WILDCAT LONG PLAT (LP-08-00024)

FINDINGS OF FACT, DECISION, AND CONDITIONS OF APPROVAL

Requested Action: William & Melva Schmidt submitted an application on June 10, 2008 for an 8-lot residential subdivision to be known as the Wildcat Plat, on 1 parcel totaling 24.32 acres of land that was zoned Agriculture 3 at the time of the application and is vested to the zoning code in place at that time.

WILDCAT PLAT
PORTION OF SECTION 32, T. 18N., R. 19E., W.M.
KITITAS COUNTY, STATE OF WASHINGTON

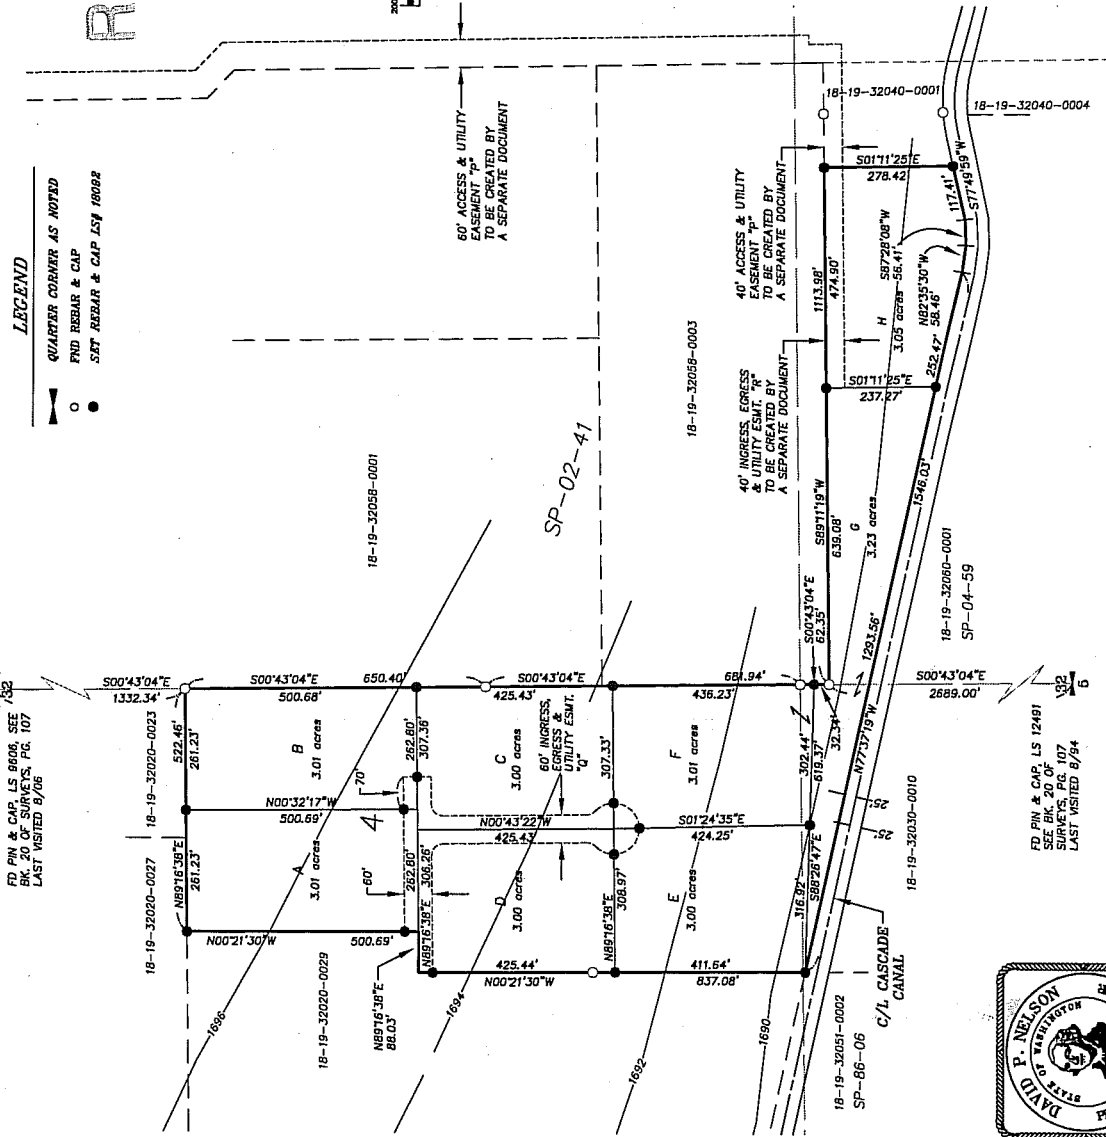
32. The following shall be updated on the final plat:
 1. For the 60’ access easement, please show public access (including recording numbers) of easements to a public right of way.

4. The owner will need to be updated on the face of the plat
 5. The access easement over lots A through F will need to have radii dimensions shown.
 6. All dimensions shall not be obscured by crossing linework

7. The contact information for the survey firm will need to be updated.
 8. It is assumed that the corners shown as found, in the preliminary plat, but do not have dimensions shown to tie them are NOT part of any survey control network utilized to determine the boundaries as shown. Please clarify this for final platting.
